Job name: Arundel Road, Angmering

Note No: C86473-JNP-66-XX-TN-T-1006-P02

Subject: Highways Technical Note to support Reserved Matters Application

Client:	Redrow Homes Limited
Job:	Arundel Road, Angmering
Title:	Highway Geometry and Visibility Splays
Classification:	FI_60_20
Scale @ A2:	1:1000
Project - Originator - Volume/System - Level/Location - Type - Discipline - Number	C86473 - JNP-66-XX-DR-T-7109
Revision:	P03

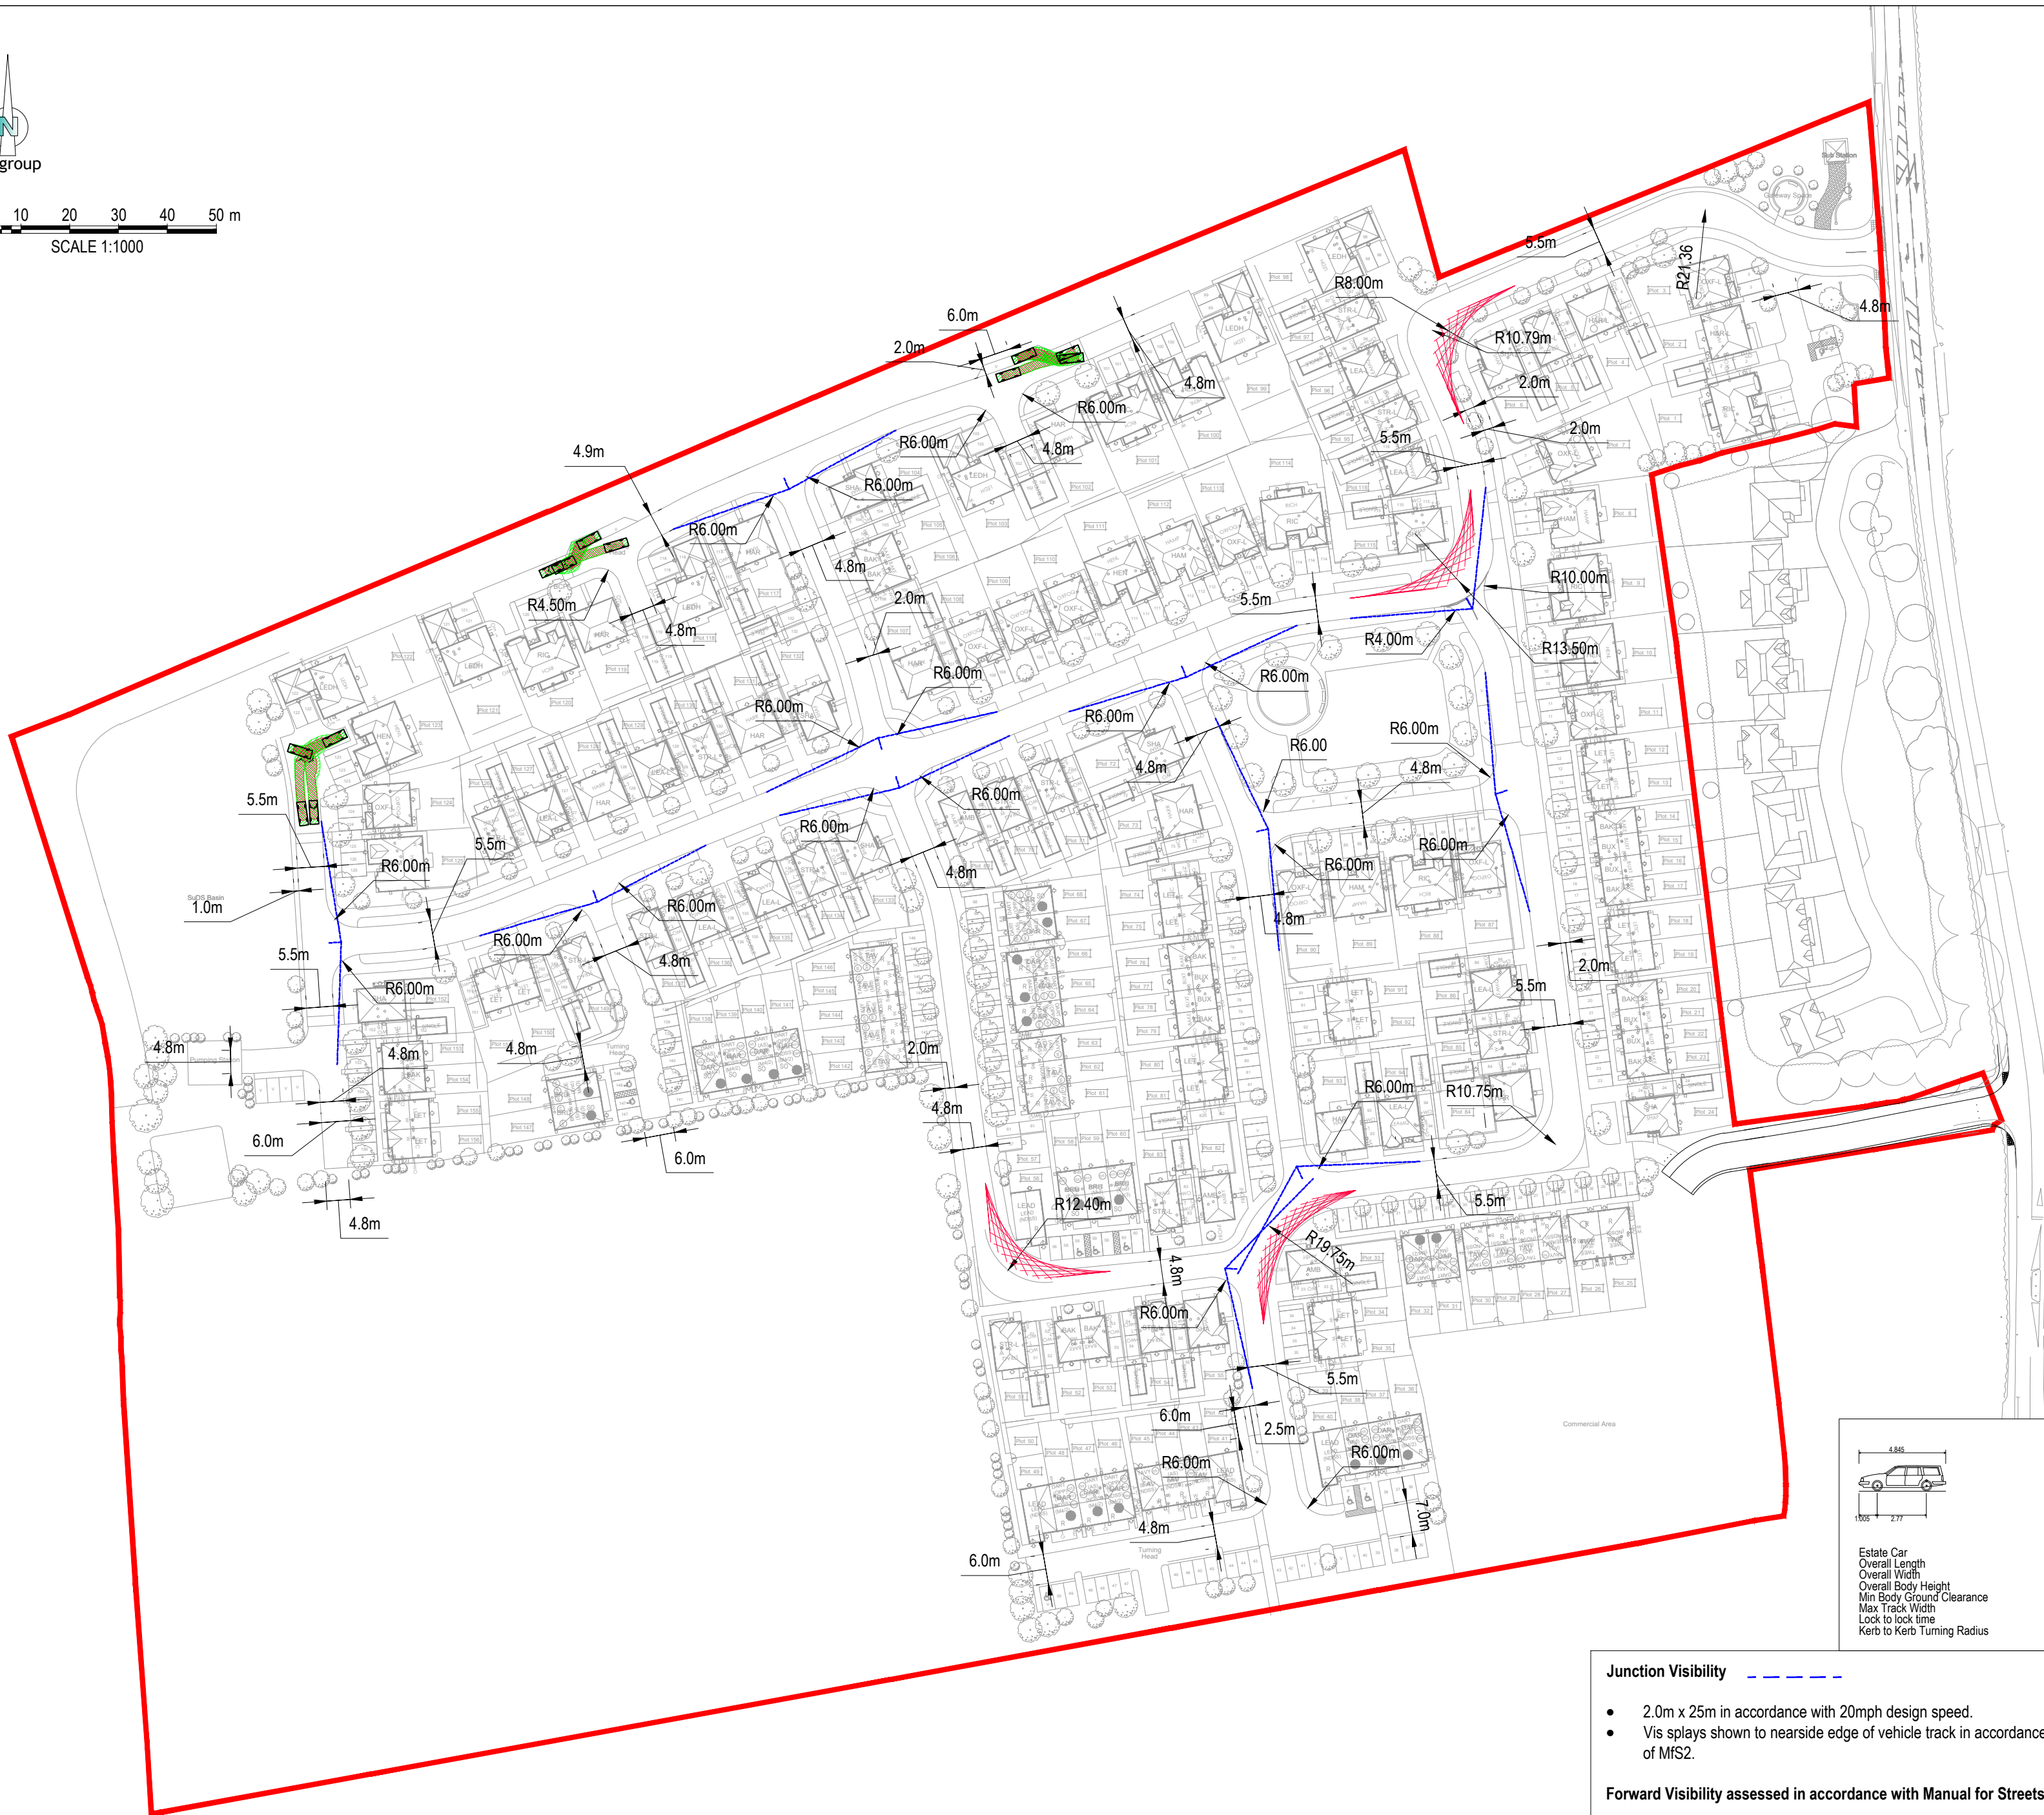
- 4.2 The previous consultation response from WSCC noted that some forward visibility splays would be obstructed by proposed planting. Further detail on the types of trees proposed and the impact on visibility was requested.

- 4.3 A review of the revised layout has confirmed that only the forward visibility near Plot 6 interacts with the forward visibility splay on the bend. It is anticipated that the planting within the visibility splay will be semi-mature 'clear stem' trees and/or trees with a high canopy. This accords with Manual for Streets Section 7.8.6, which states the following:

Refuse Entry, Estate Car Egress Near Plot 6 (Scale: 1:500)

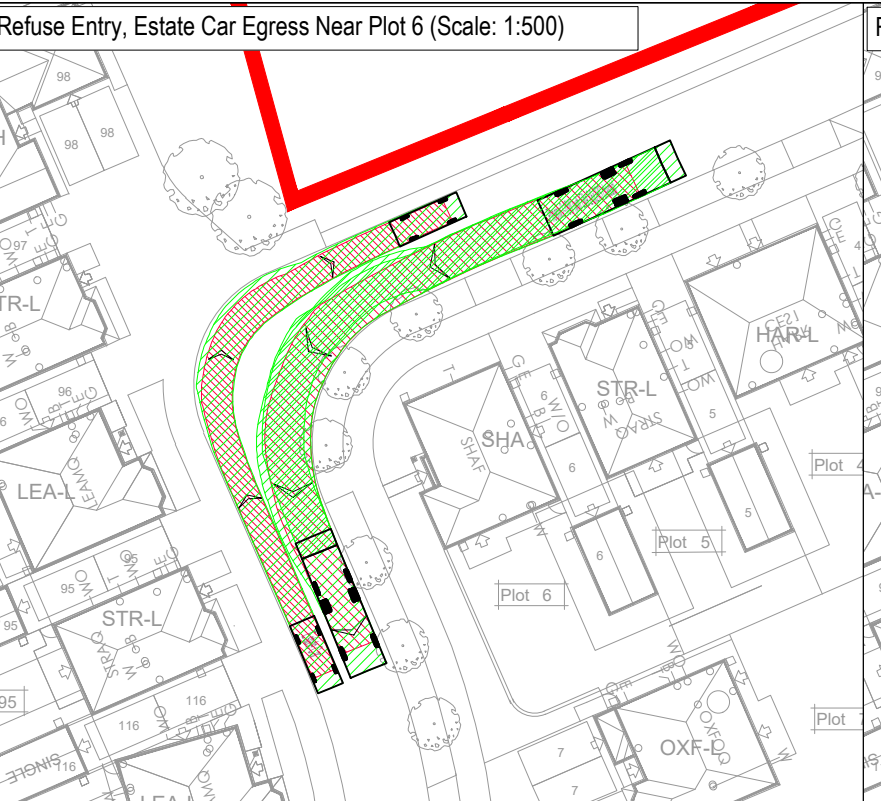
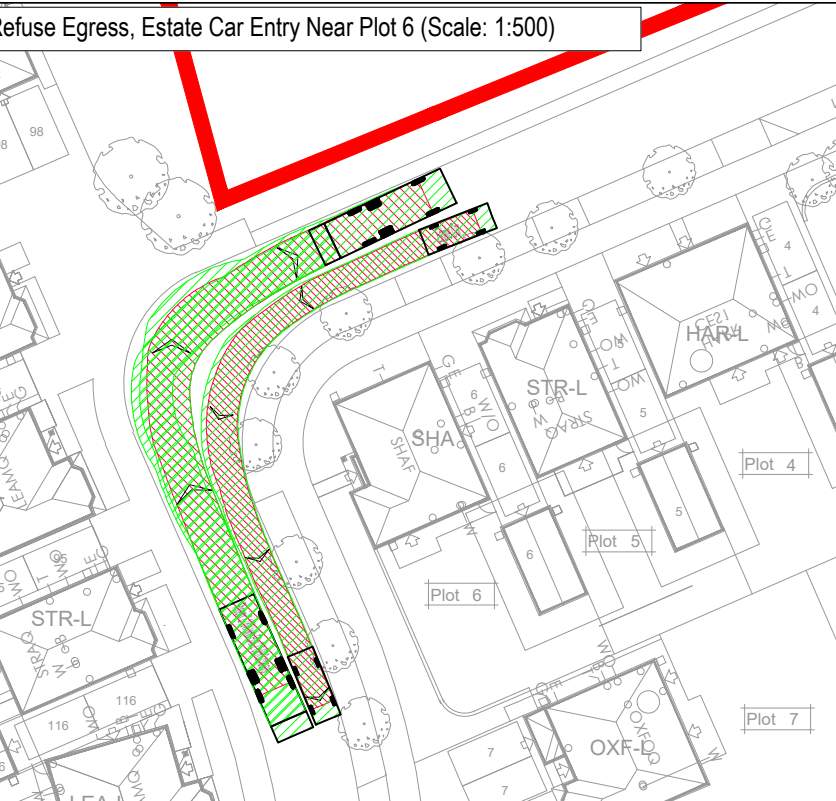
3. No crossing point to be provided to allow north/south movement close to the northern access;
 4. At the outline stage indicative plans showed a ped cycle route to the north of the POS, in the RM application the only a grass link is provided. Further information should be provided

- 3.3 It is noted from WSCC's previous comments that a crossing point was not provided near the north access to facilitate pedestrian movements. A break in the verge on the east side of the access road, near Plot 6, has been incorporated to allow pedestrians to cross informally to the footway on the west side of the access.
